DRB Application No.: 05DRB-01290 (SBP)

Project #: 1004100

Project Name: LA CUEVA VILLAGE UNIT 1

TO: Sheran Matson, DRB Chair
FROM: Carmen Marrone, Senior Planner
RE: Project #1004100, Children's Learning Center

PARKING LOT CALCULATIONS

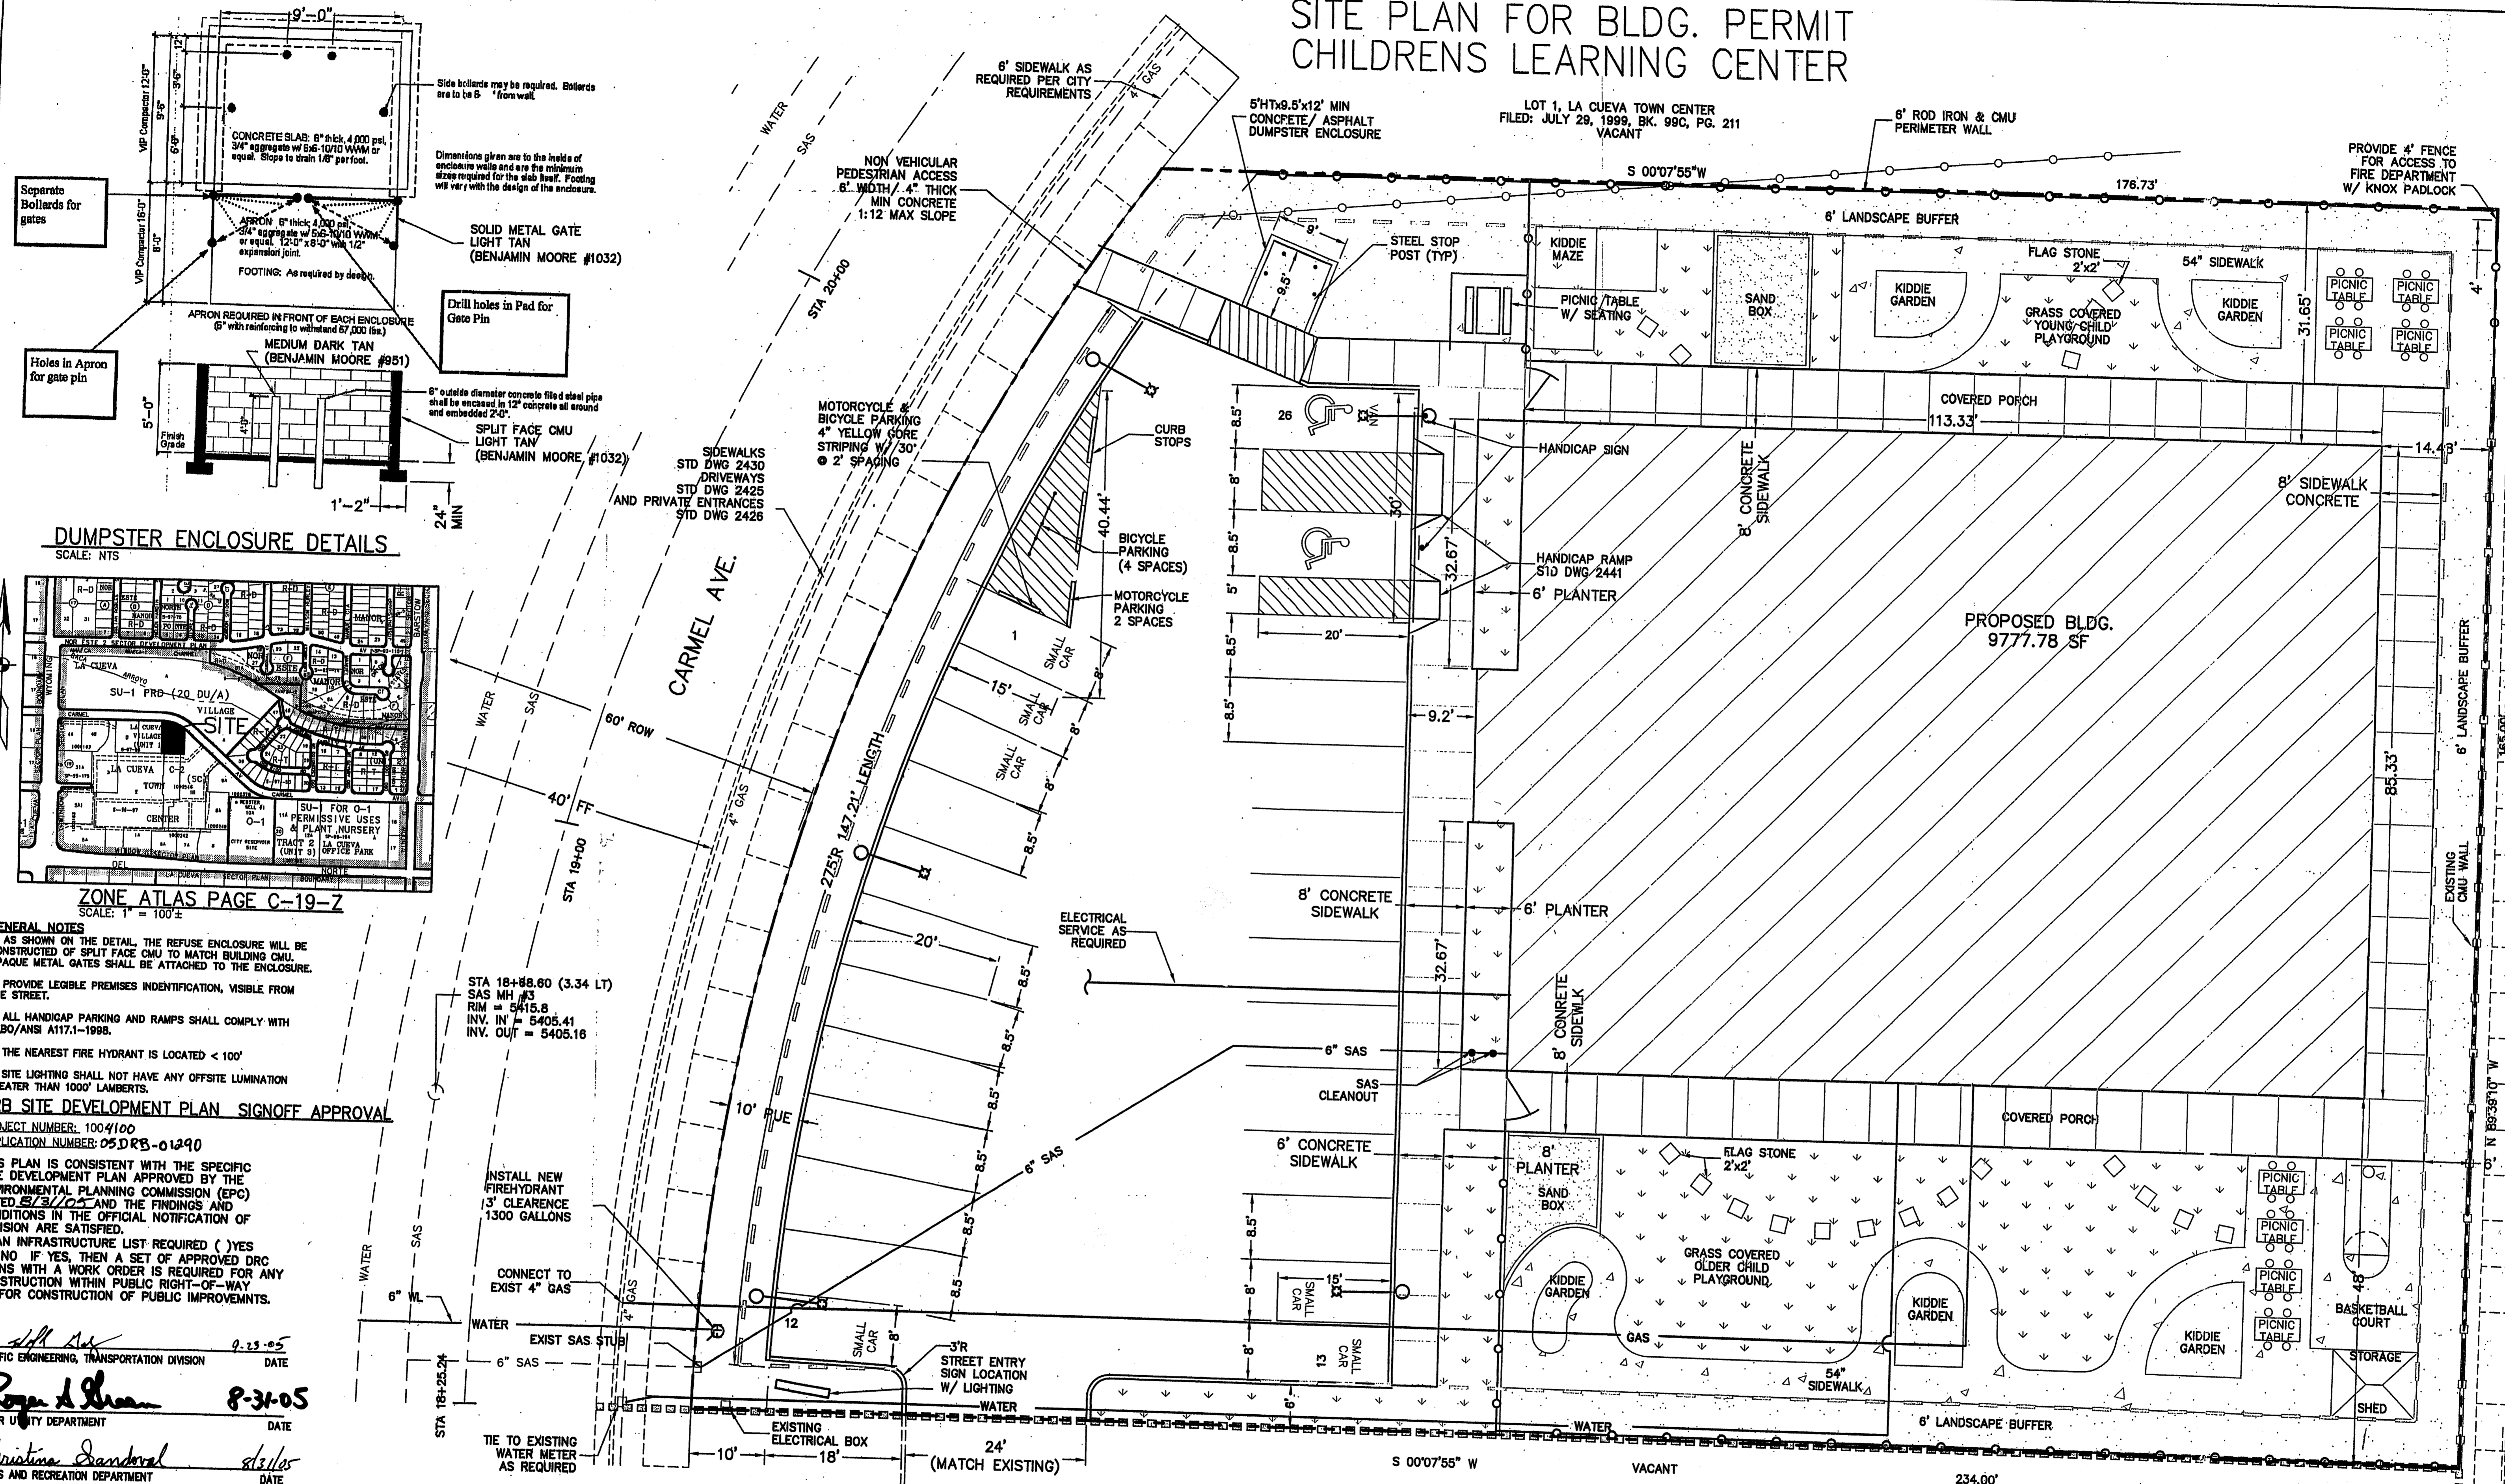
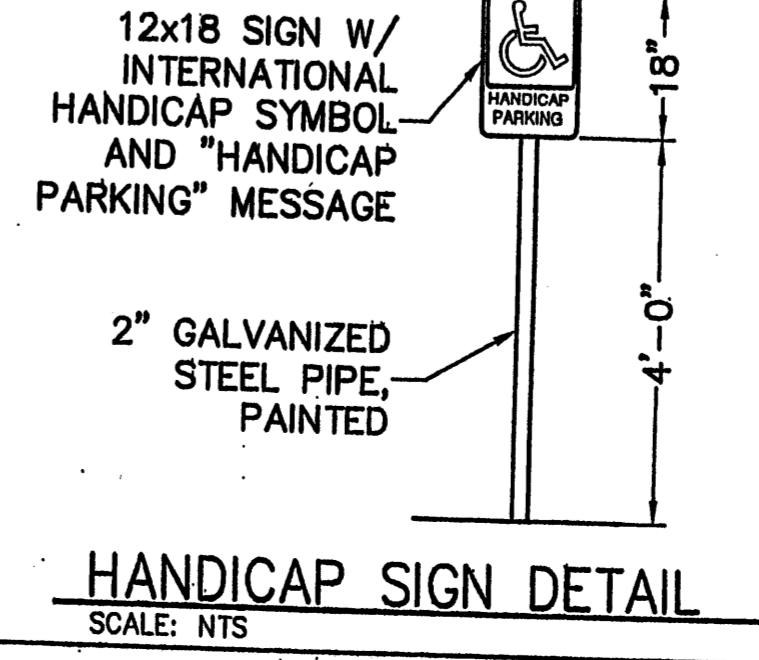
Condition 3: When measured, some of the small car spaces are less than 8 feet wide and some are more than 8 feet wide. Some adjustments may need to occur in order to obtain a minimum width of 8 feet for small car spaces. The total amount of small car spaces, as shown on the site plan, is 6 not 5 and the total amount of parking spaces is 26, not 25.

TRANSPORTATION: PROVIDE X-ACCESS AGREEMENT ✓

DUMPSTER ENCLOSURE DETAILS

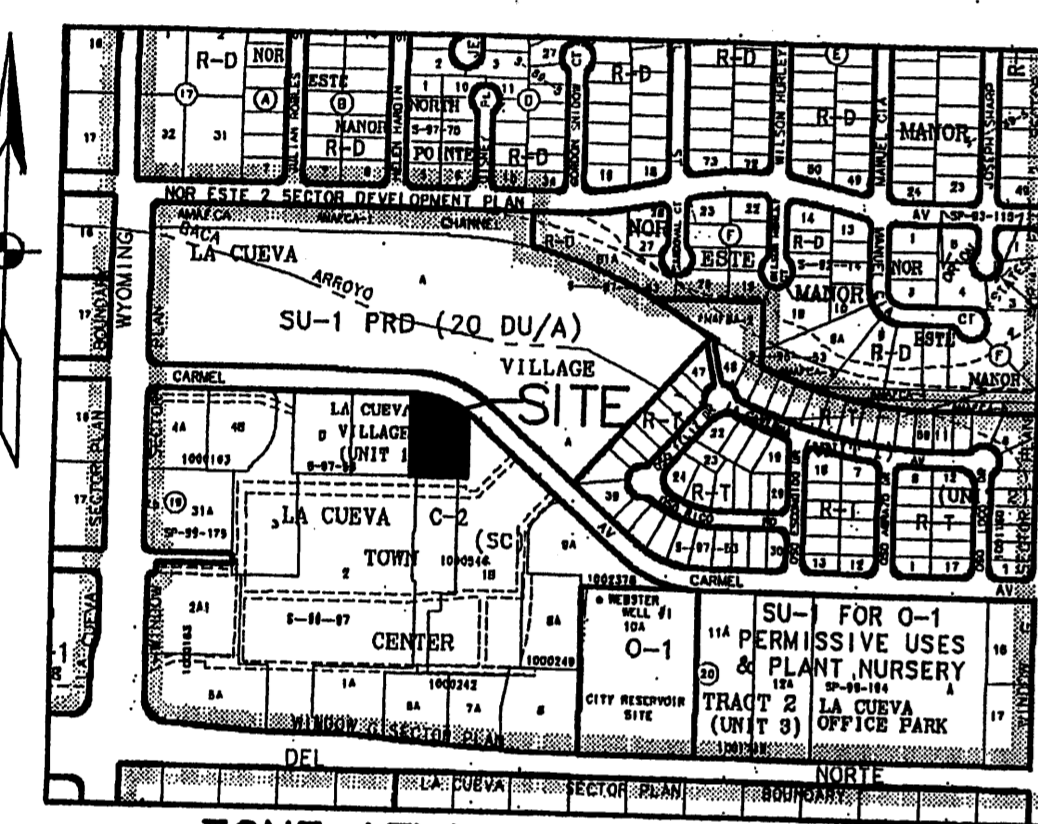
Condition 2 calls for the refuse container to be a maximum of 5 feet in height. The site plan indicates a total height of 6 feet. Also, a note on the site plan indicates an attached letter containing further solid waste dumpster information. No such letter is in the file.
